A63 Castle Street Improvement, Hull

TR010016

Applicant's comments on additional information or submissions received by Deadline 5

Version	Date	Status of Version
Rev 0	27 August 2019	Final

Levels Study - Existing

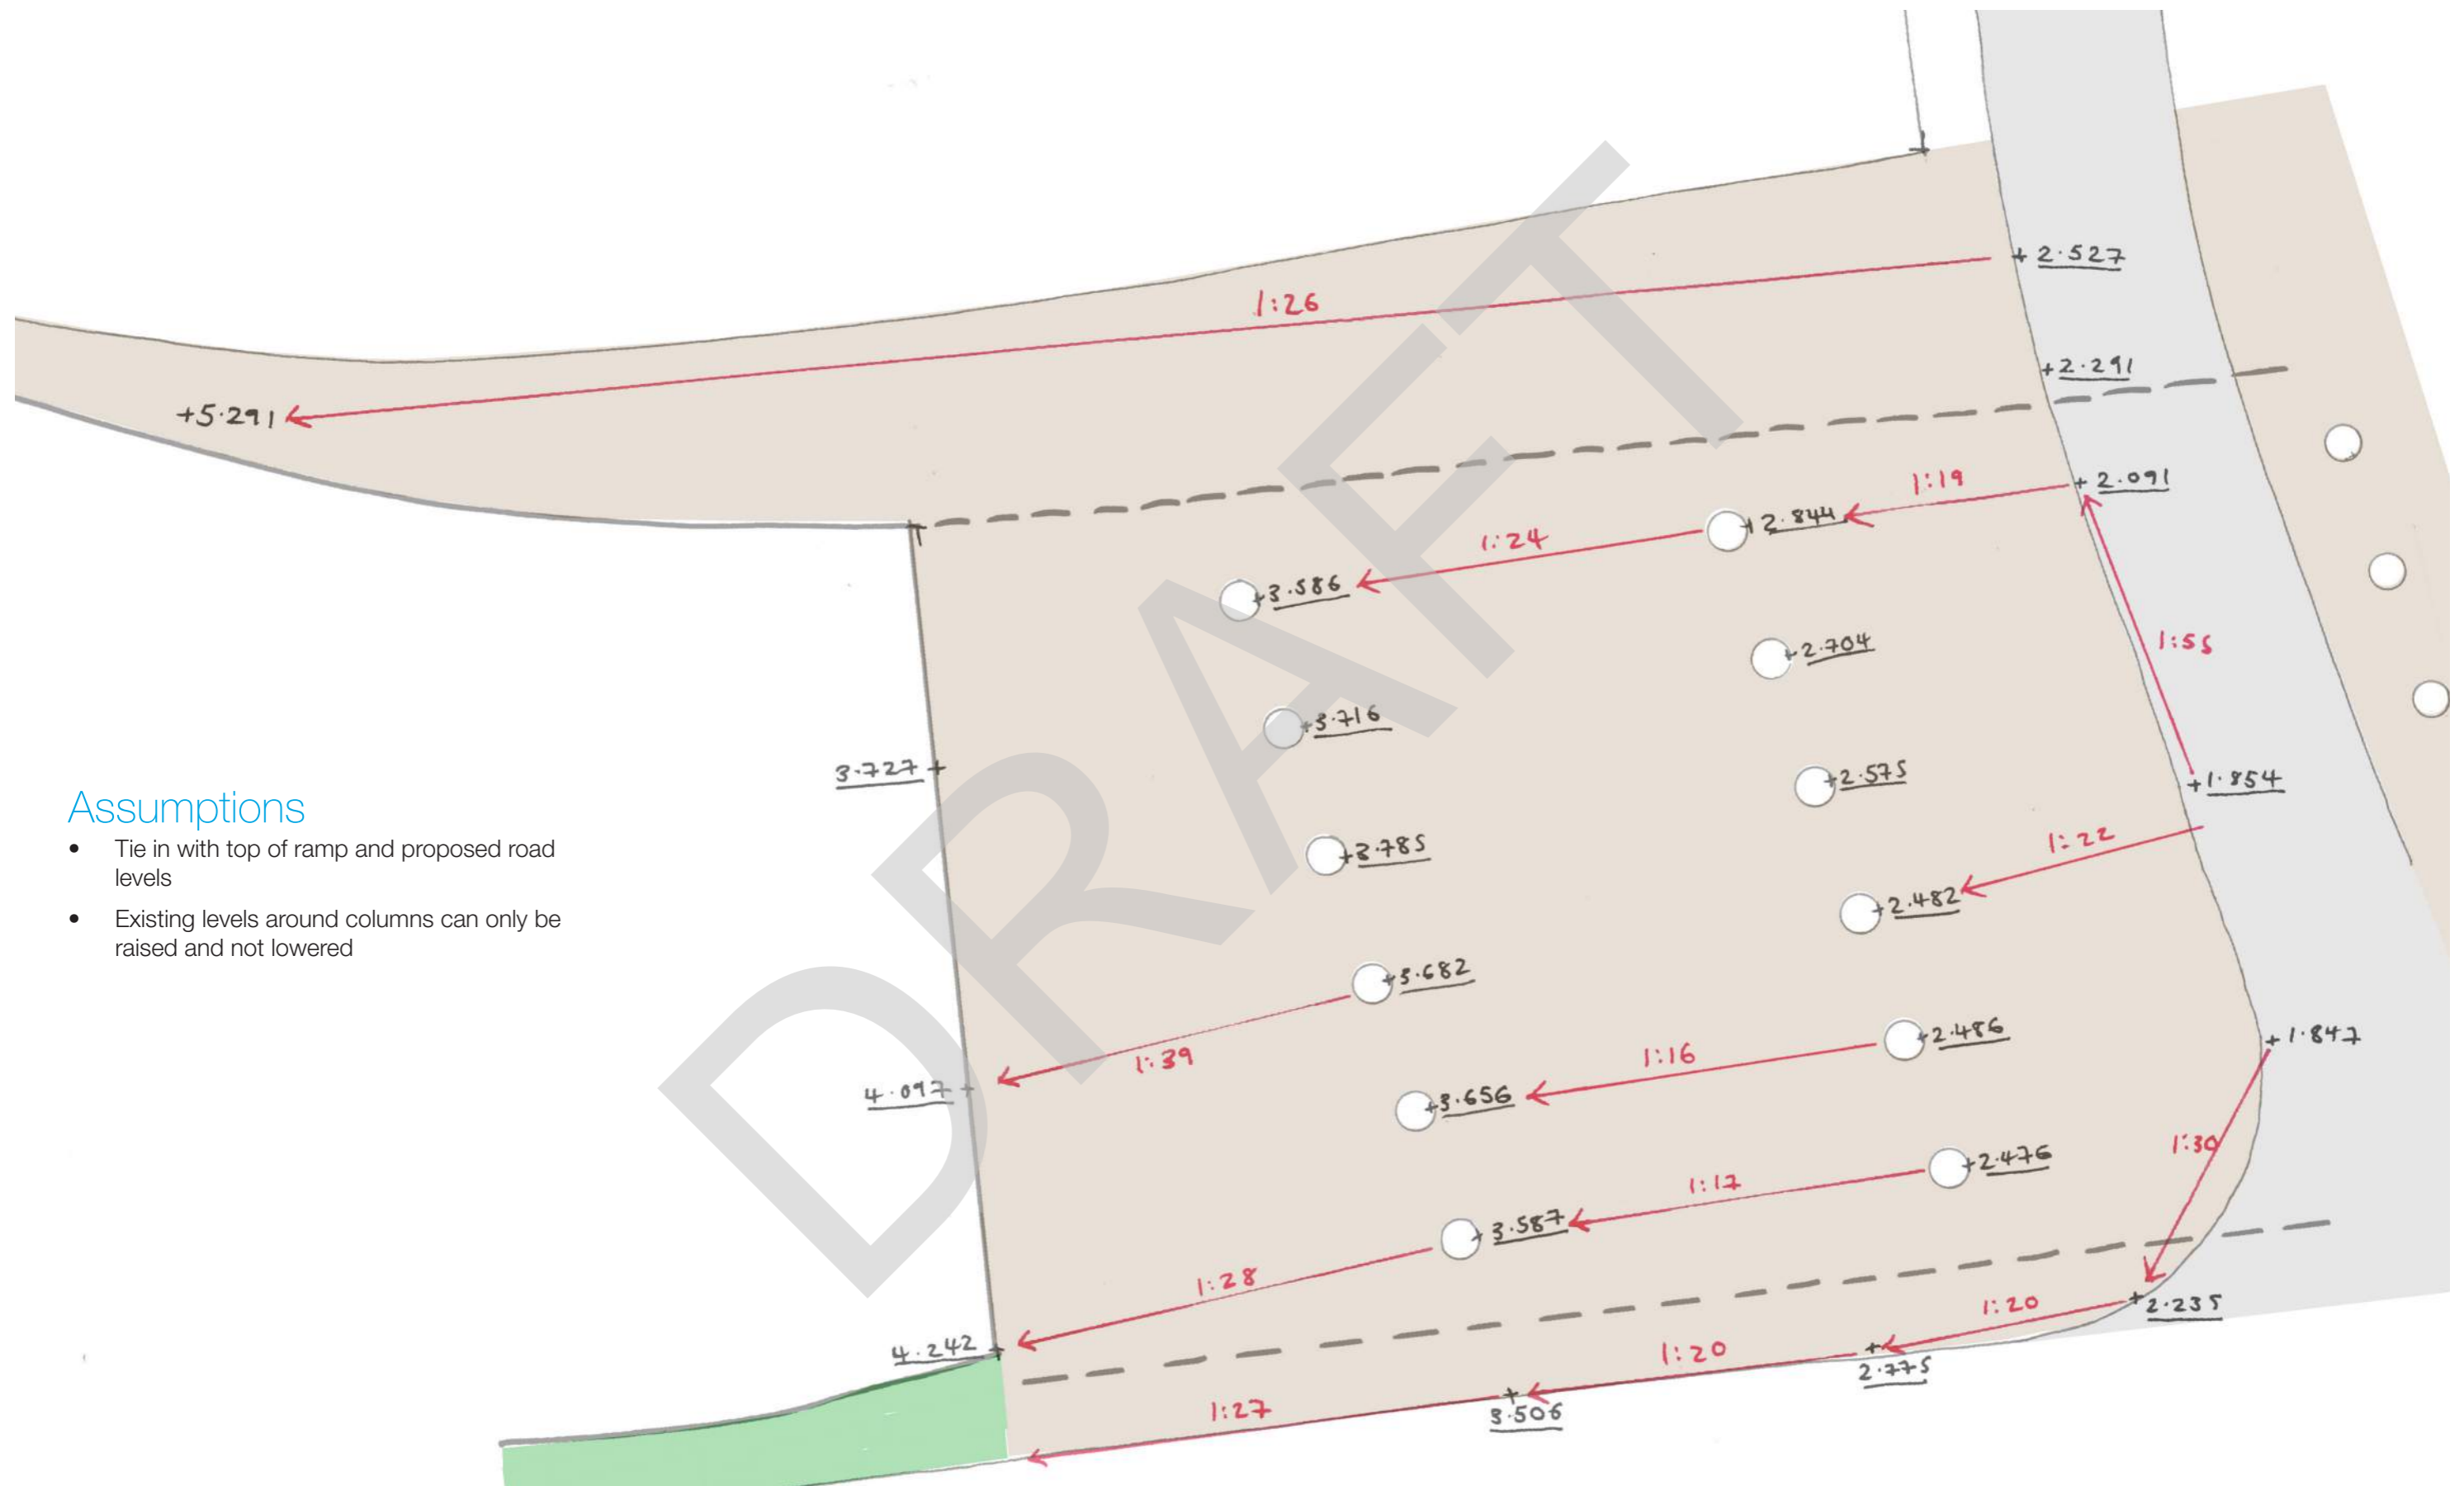
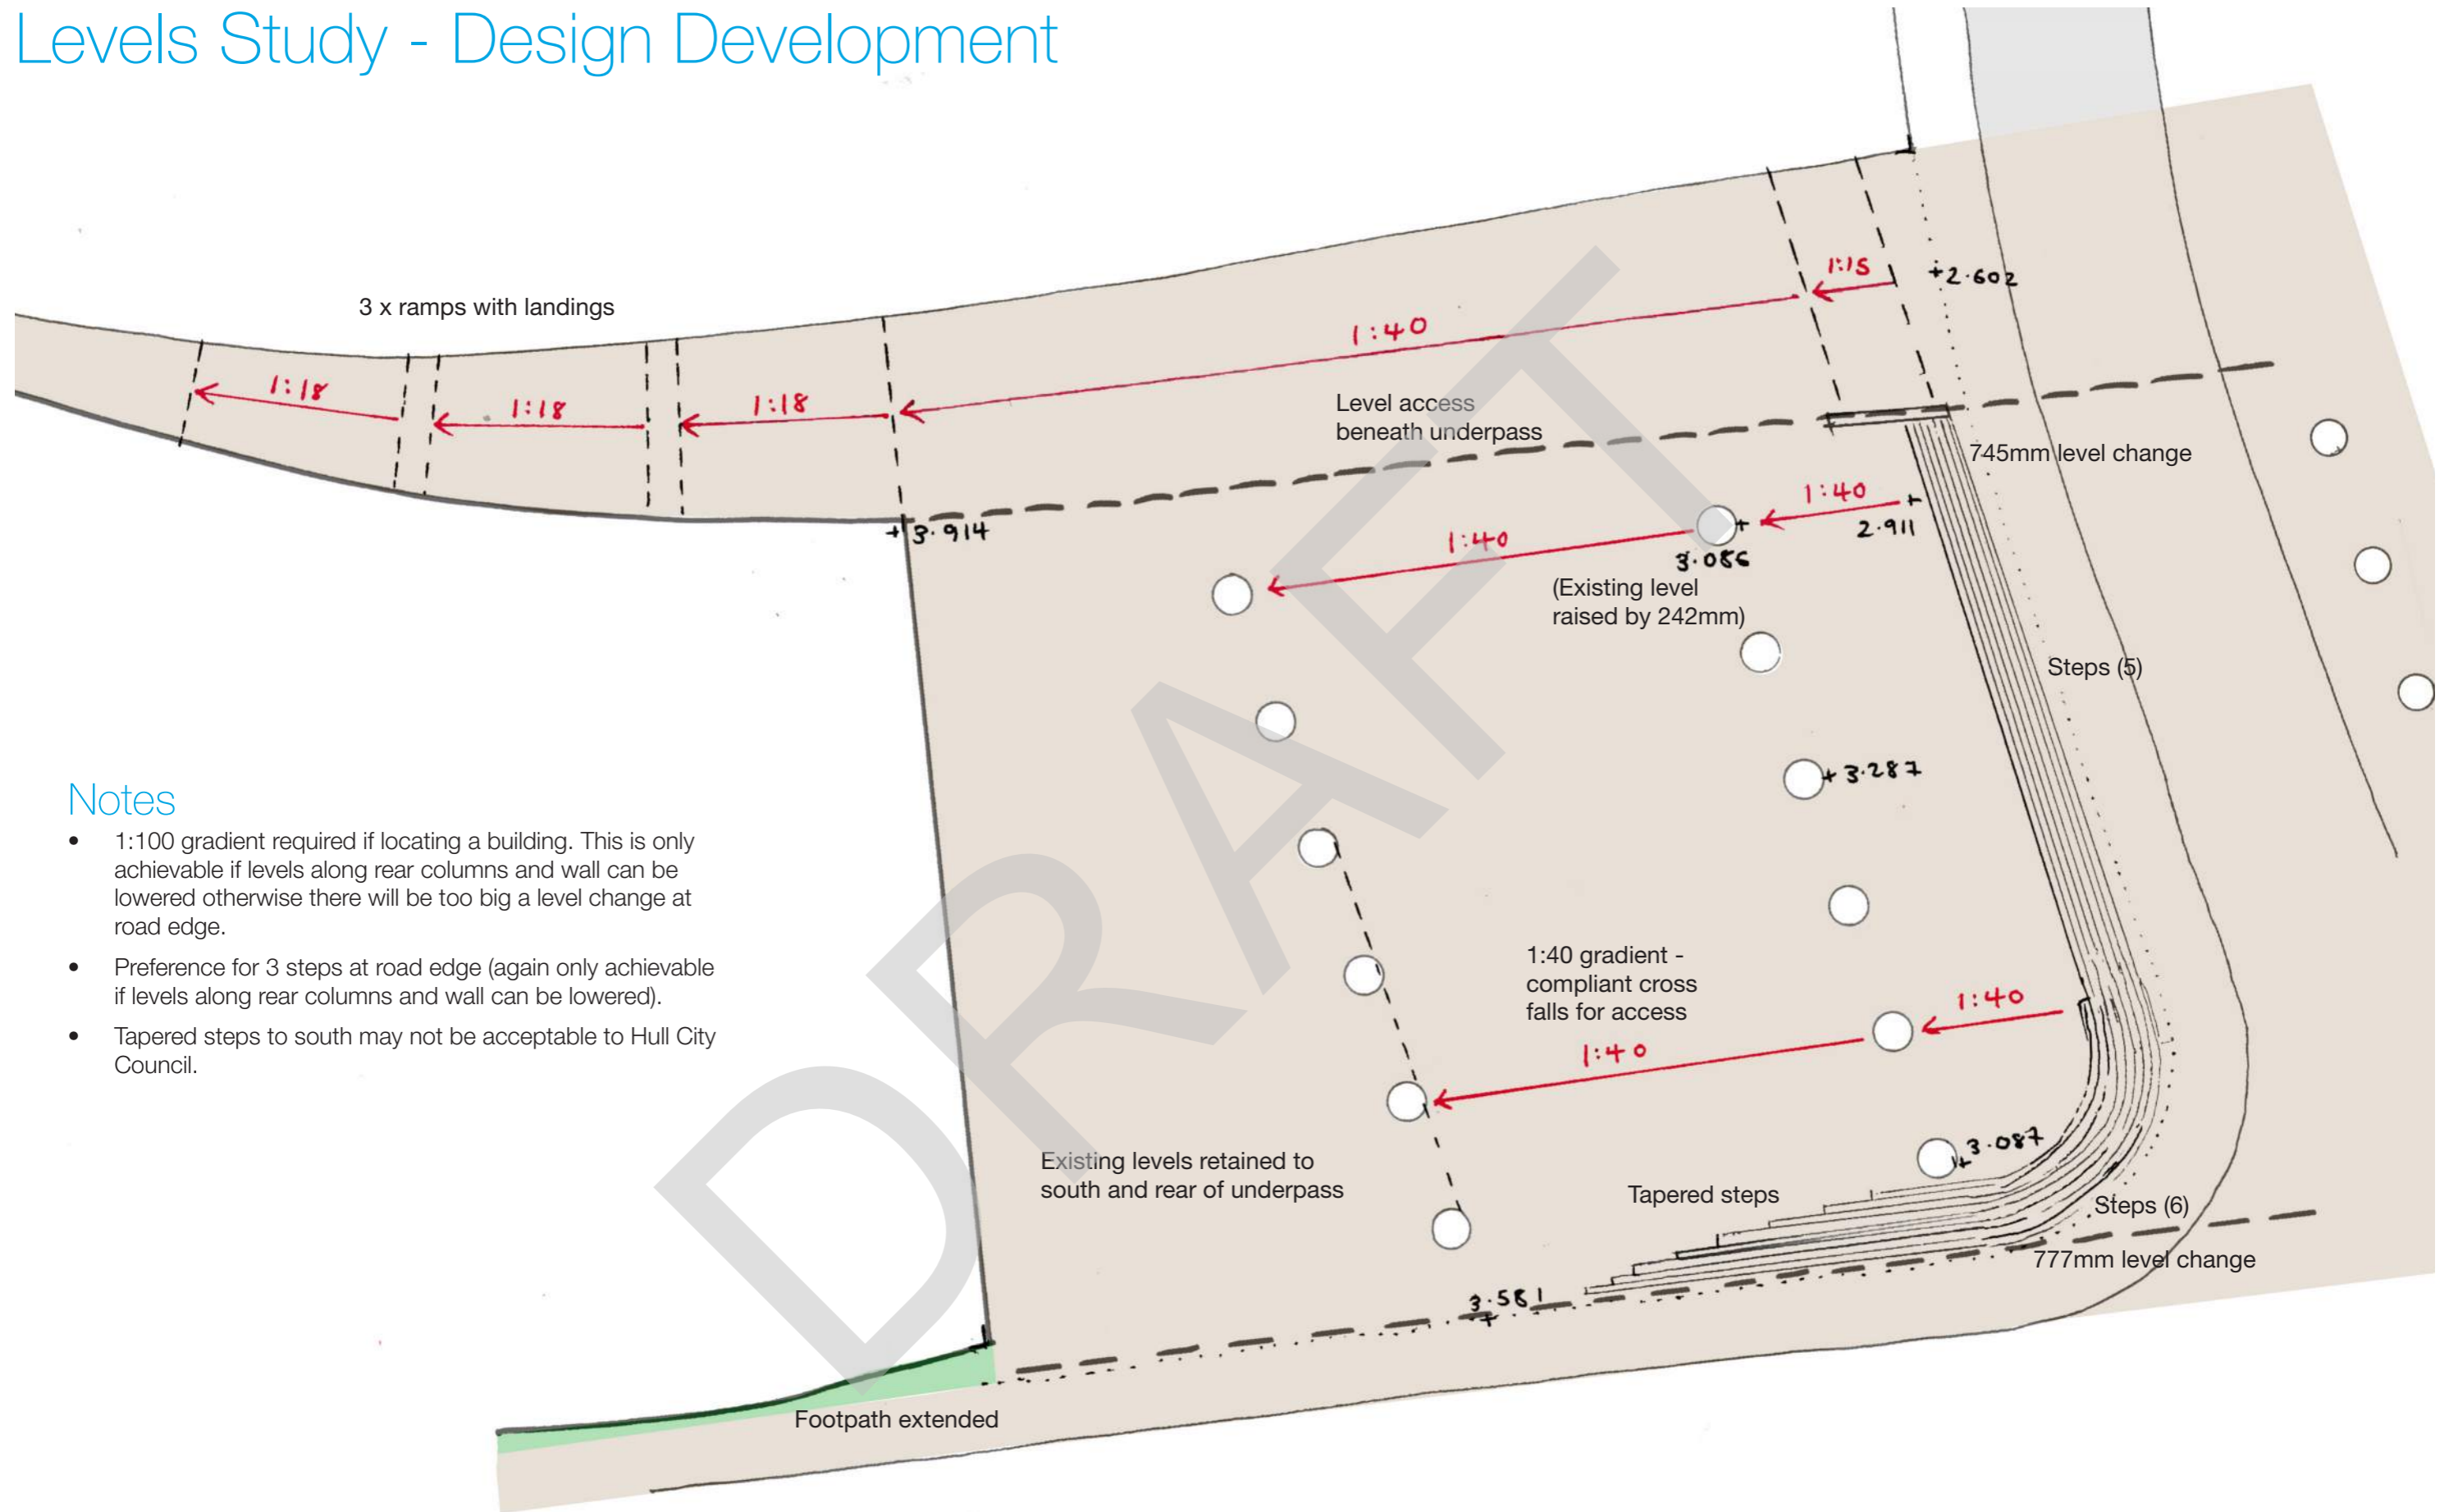
ExQ2	Question to:	Question:	HCC response
2.7	Transportation and Traffic		
2.7.2	The Applicant, HCC, HAIG, East Yorkshire and Derwent Area Ramblers	<p>Myton underpass design</p> <p>The Council's suggested additional requirement, which would require details of the design of the Myton Bridge underpass, is noted (HCC's Post-Issue specific Hearings submission [REP3-215]). Have any design principles or details yet been agreed? If not, what evidence is there that a mutually satisfactory design can be achieved?</p>	<p>HCC wishes to reiterate that this element of the scheme remains a distinct and fundamental concern. Given the removal of at grade NMU crossings over the A63 at the eastern end of the city centre, this route is set to become critical in connecting the city centre to its waterfront and associated regeneration areas, and providing an accessible alternative for all users, both during construction and operation.</p> <p>HCC consider that an environmental upgrade of the underpass is justified and necessary for the scheme to deliver truly on its objective to enhance connectivity, and mitigate for extended travel distances for NMUs, and comply fully with the DfT's Cycling and Walking Investment Strategy, the Applicant's Accessibility and Cycling Strategy, paras.3.16 and 3.17 of the NN NPS, and Policy 25 of the Local Plan.</p>

ExQ2	Question to:	Question:	HCC response
			<p>In the continued absence of sufficient design details for the proposed base scheme, and reliance on frozen designated funds for uplift, notwithstanding constructive consultation around the issue with the both council officers and representatives from HAIG, including a beneficial walk through held on 2nd July, and discussion around broad design principles at a subsequent landscaping design meeting, HCC consider that it is essential that the additional requirement features within the DCO.</p> <p>The Council and its partners in the 'Living with Water' project have identified the underpass as a location suitable to benefit from secured public art funding associated with flood risk and water management. Adjacent to the River Hull and near to its confluence with the Humber estuary, in the shadow of the River Hull tidal surge barrier, and on one of the main pedestrian approaches to the Deep aquarium, the site is considered to have great potential, and the Council is very keen to work with the Applicant to pool ideas and resources towards maximising the quality of experience for route users.</p>

<p>HCC note the following <i>'in the continued absence of sufficient design details for the proposed base scheme, and reliance on frozen designated funds for uplift, notwithstanding constructive consultation around the issue with the both council officers and representatives from HAIG, including a beneficial walk through held on 2nd July, and discussion around broad design principles at a subsequent landscaping design meeting, HCC consider that it is essential that the additional requirement features within the DCO'</i>. It should be noted that preliminary design (of which the DCO is based on) has been shared with all parties, including HCC and HAIG. Meetings have been held in a workshop format and on site and the feedback on the proposals was overwhelmingly positive. Detailed visualisation were also presented to all parties which again were well received. The comments from the group centred around the step detail on the corner Blackfriargate and High Street which will be picked up at detailed design stage.</p>

<p>The Applicant's Response 2.7.2</p> <p>The Applicant notes the importance of the High Street underpass to HCC as the proposed route around Market Place crossing closure. The Applicant has worked very closely with HCC highways officers, access officers, HAIG, designers and developers adjacent to this route during the scheme development. Workshops have been held, a walk with HAIG was held and visualisations for the route have been prepared and shared. They have been appended to The Applicants D6 submission for the ExA to consider.</p>

ExQ2	Question to:	Question:	HCC response
		<p>The base scheme proposals, therefore entirely funded by the Scheme, indicate that the route between Market Place and Queen Street will be upgraded to:</p>	<ul style="list-style-type: none"> - Improve accessibility in line with guidance (dropped crossings and smoother ramp gradient); - Provide enhanced street lighting and urban lighting (up / down lighters for the bridge piers) on the route; - Improve the footways and align this with material used following the significant public realm work completed by HCC; - Provide CCTV infrastructure; - Cut back the levels of overgrown vegetation and provide a new low maintenance planting proposal for the route.
		<p>The visualisations provided by The Applicant show that this area is to be significantly improved compared to current levels. The Applicant, by agreeing to uplift the footway material and provide additional up/down lighters under the structure is going above and beyond of the minimal provision that would be expected. This has been agreed between The Applicant and HCC as it will become the only way for people to cross between the north and the south of Castle Street in this vicinity.</p>
